Dean Moor Solar Farm

Environmental Statement: Chapter 7 – Figure 7.6 1-5 Landscape Strategy Plan on behalf of FVS Dean Moor Limited

26 August 2025
Prepared by: Stantec UK Ltd
PINS Ref: EN010155
Document Ref: D2.28
Deadline: 2
Revision: 2

Project Ref:	EN010155/6.2 ES Figure 7.6.1-7.6.5 Landscape Strategy Plan
Status	Final
Issue/ Rev:	2
Date:	August 2025

Environmental Statement: Chapter 7 – Figure 7.6 1-5 Landscape Strategy Plan on behalf of **FVS Dean Moor Limited**

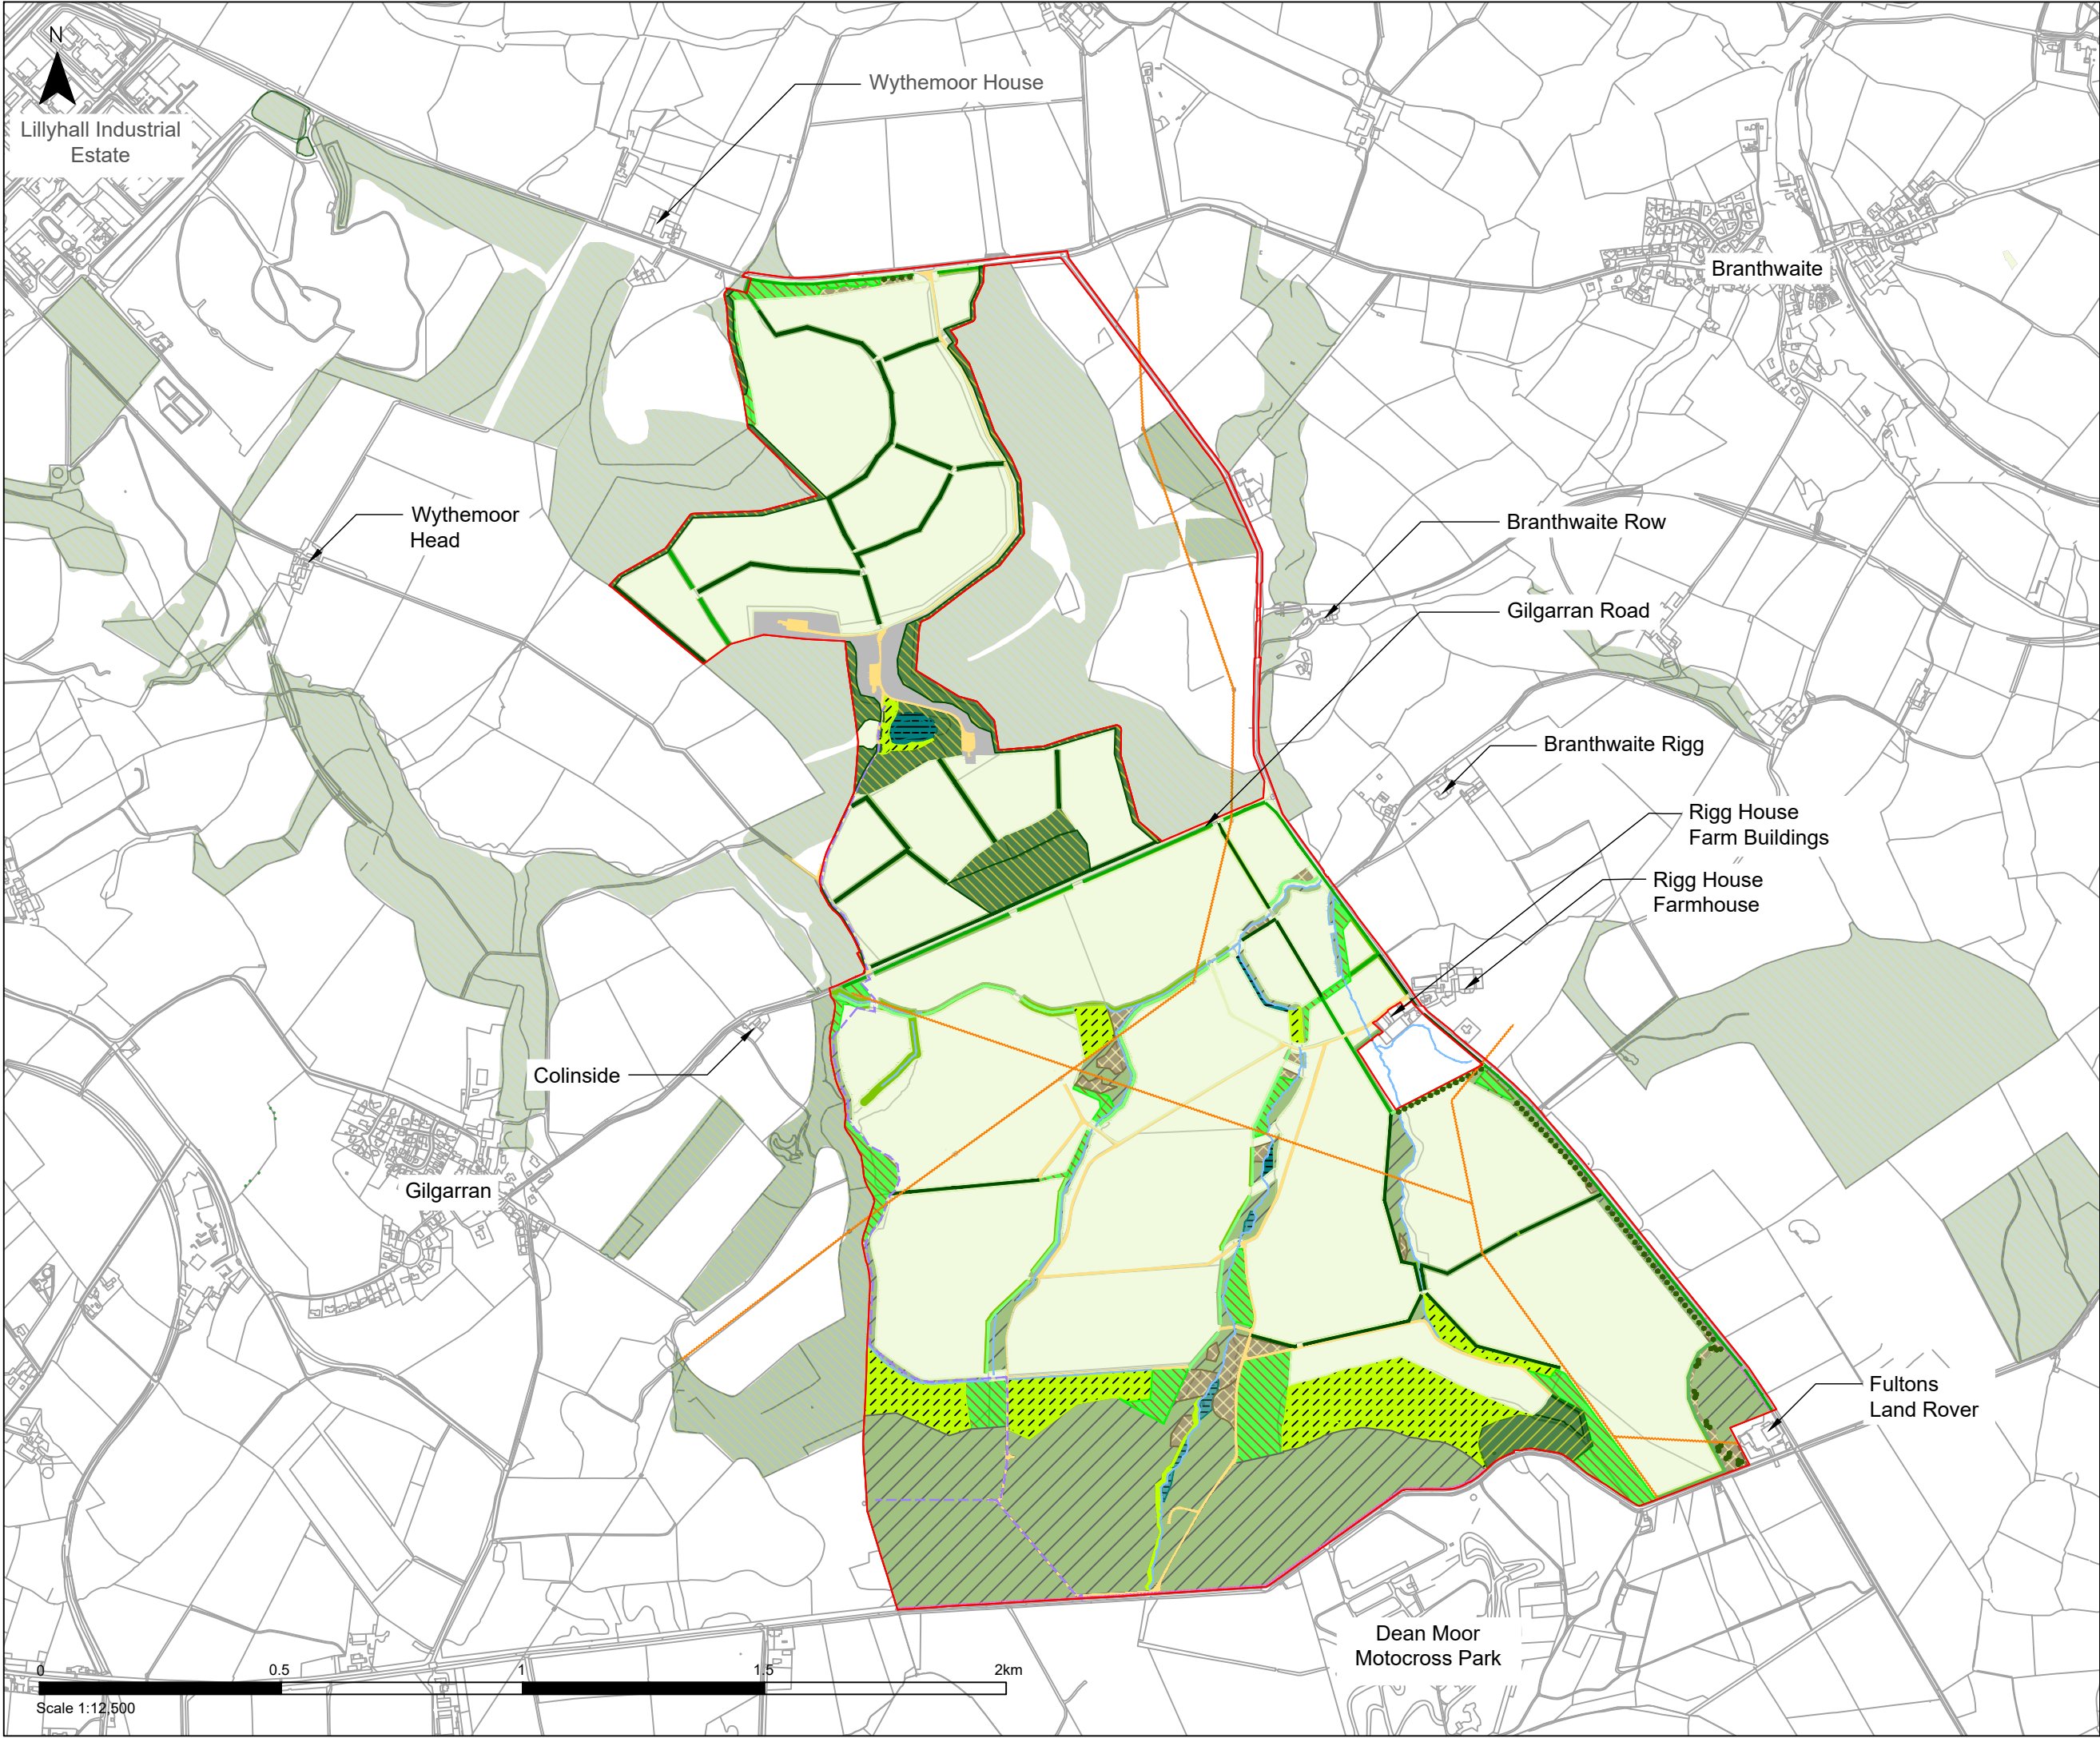
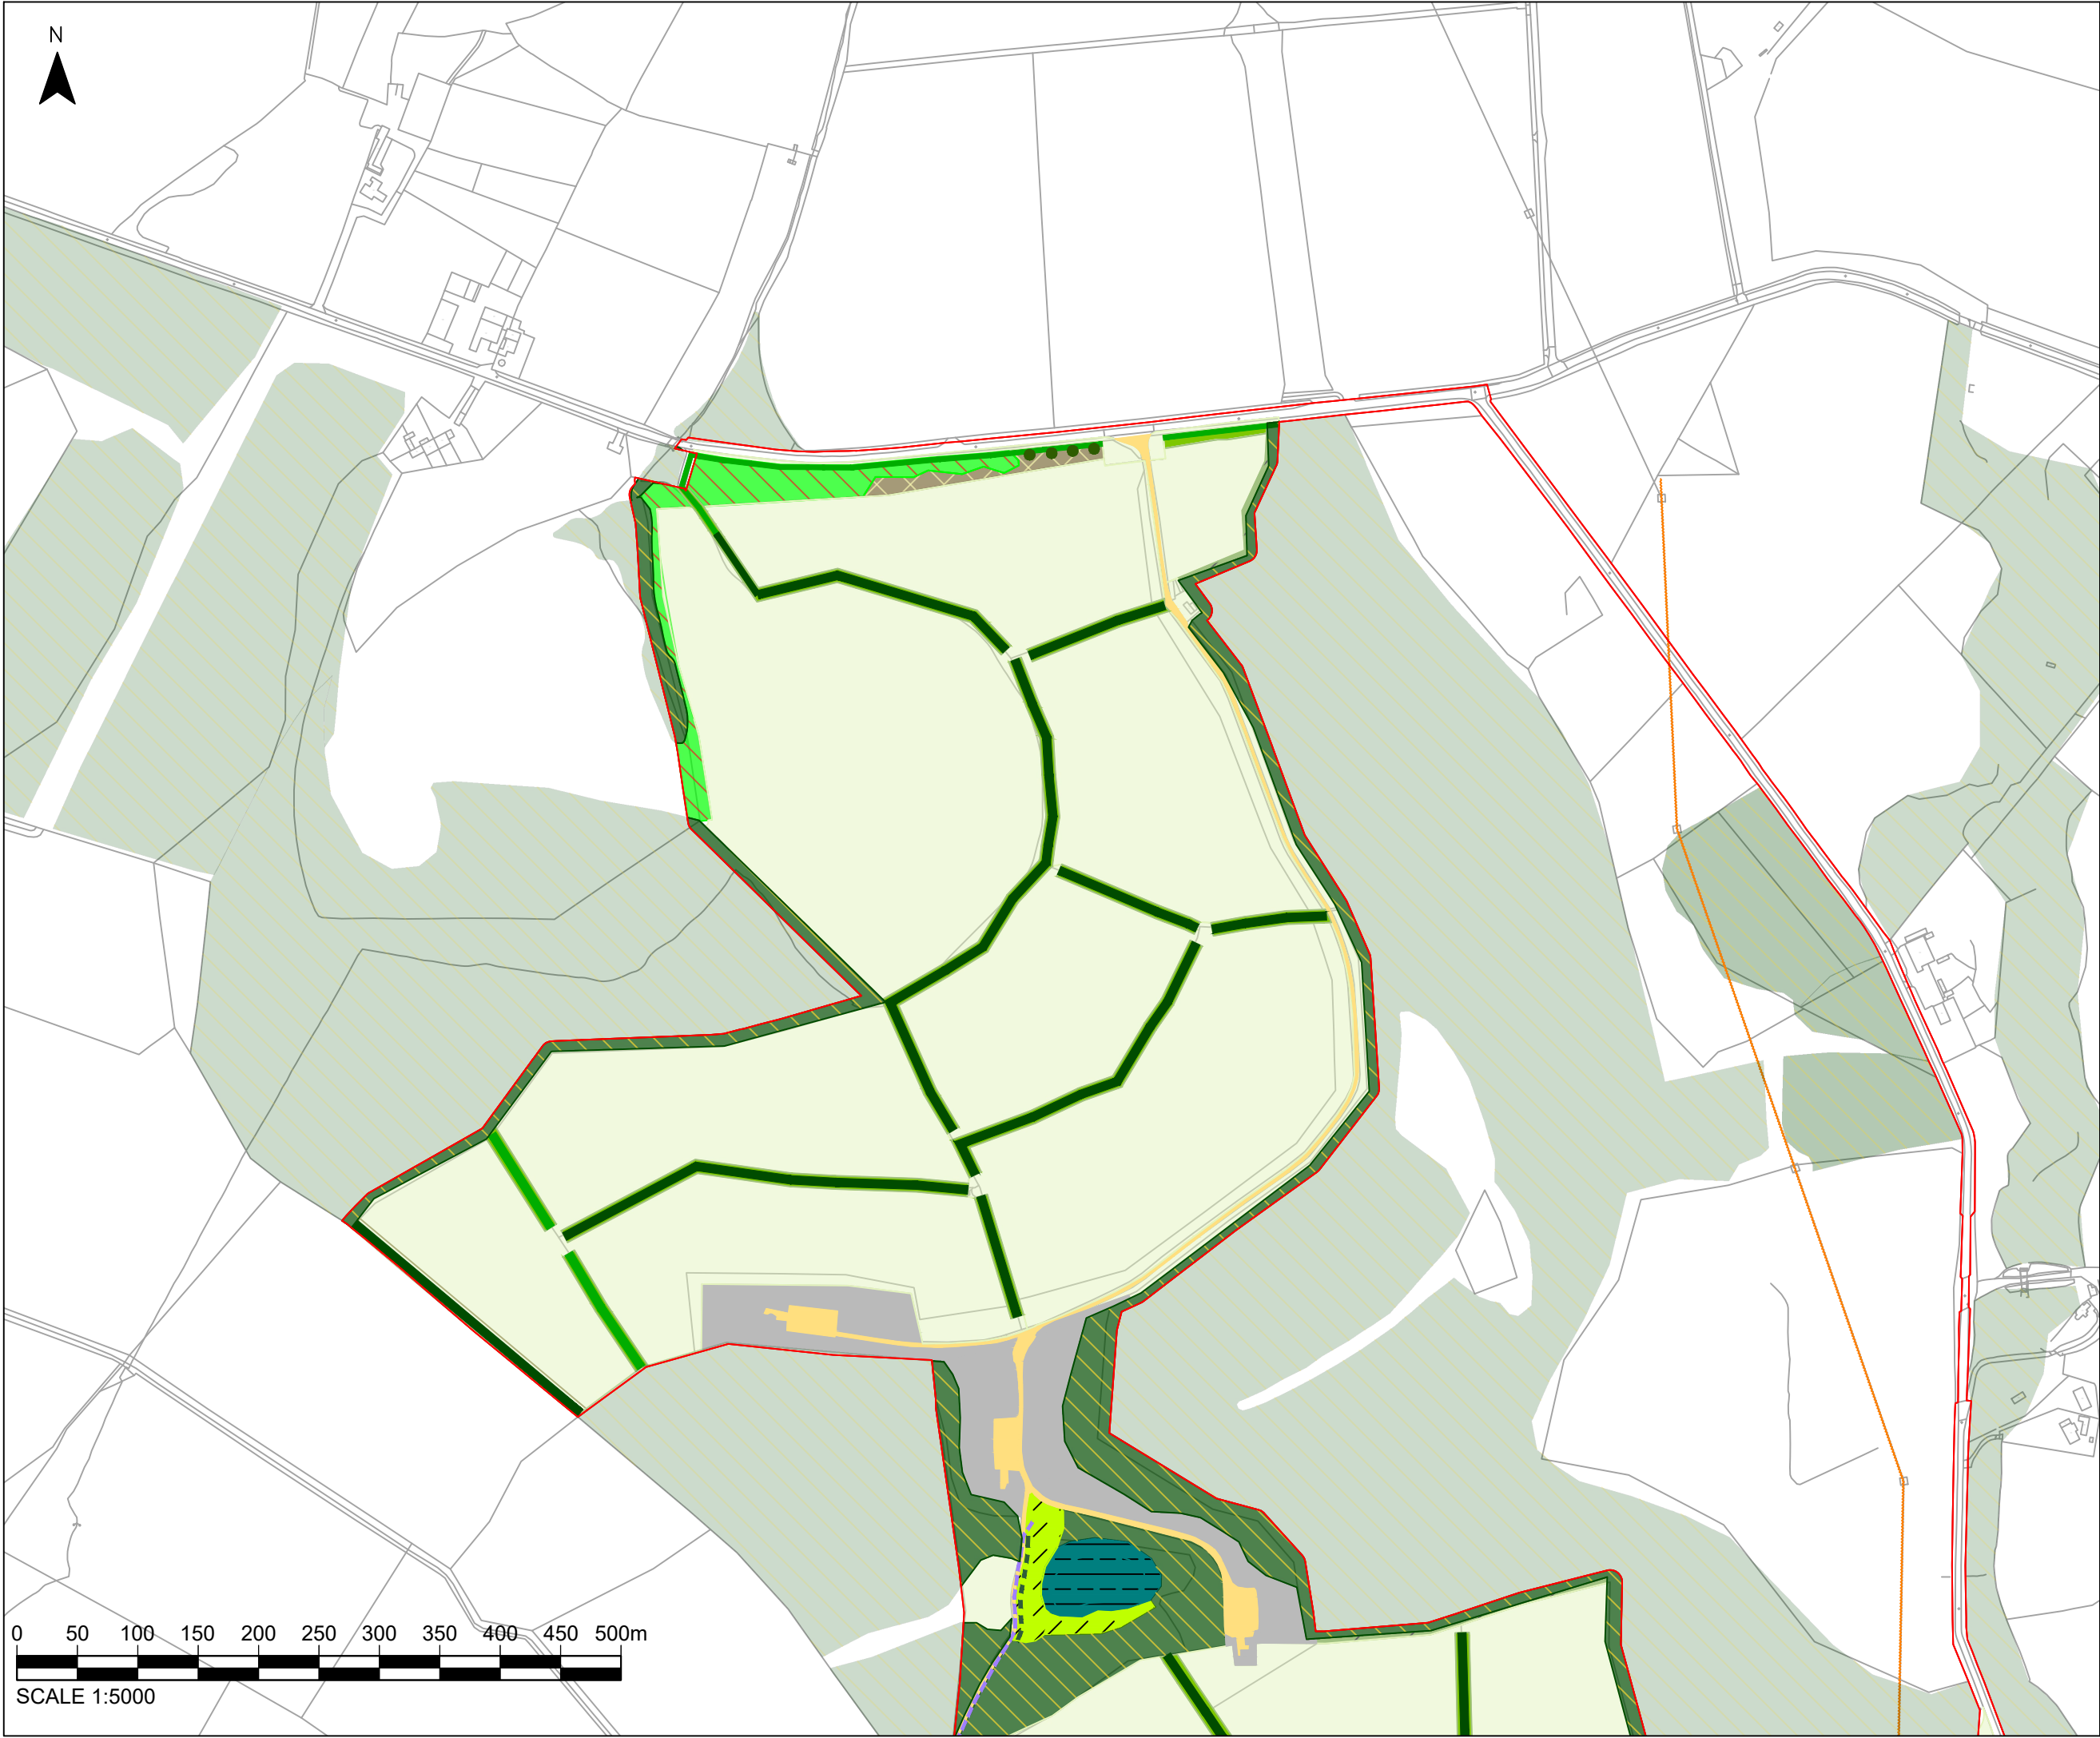
Revision	Reason
Dry stone wall line-style updated to darker purple and dashed	<p>Q6.0.2 of the Examining Authority's (ExA) first written questions stated:</p> <p><i>"The Landscape Strategy plan [APP-088] includes a number of colour coded features which are similar and difficult to discern (for example, existing and proposed hedgerows). Please amend."</i></p>
Willow screening hedge line-style changed to smaller dash and changed from green to reddish/brown	
Existing woodland (Coniferous) updated to crosshatch (easier to distinguish between coniferous/broadleaved)	
Acid grassland hatch changed to differentiate better between this and existing woodland	
Native planting to protect watercourse changed colour to darker blue	
Marginal planting hatch colour made slightly lighter blue to distinguish between this and native planting to protect watercourse	
All hedge line-styles/colours changed to make it easier to distinguish between them

Other grassland colour made lighter	
Broadleaf woodland hatch changed to distinguish better between grassland and woodland colours
